**Objection to the Discharge of Conditions on the “Nyton Stables “
development, (AL/23/17/DOC)**

It is on these grounds that we object to any further illuminations being discharged in this application **(AL/47/14/PL)** until this matter is addressed. Further lighting on this development will only make this matter worse.

Condition no.10.

Tree and Hedge Planting

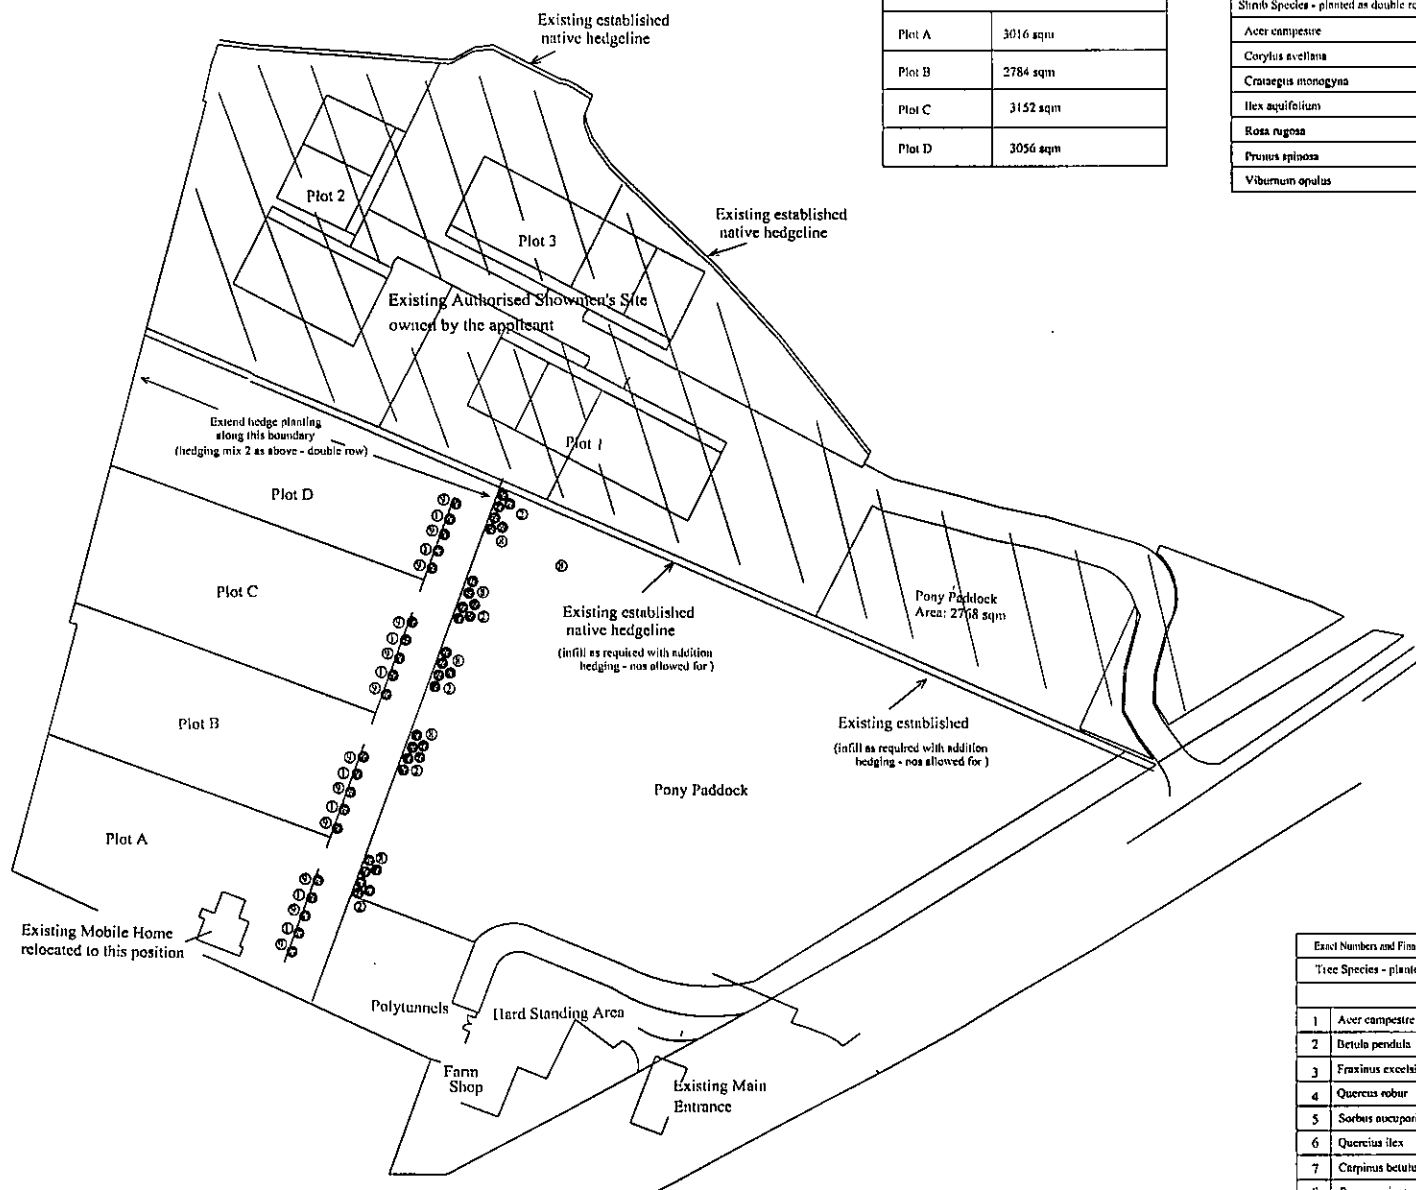
Over the past year, we have endured from this development blazing column lights and associated domestic lighting, penetrating the night where before there was darkness, and this has been a serious intrusion on the lives of ourselves and our neighbors in Marsh Lane. We have a complaint being dealt with at the moment regarding this, and the lack of adequate boundary landscaping that might afford us some protection.
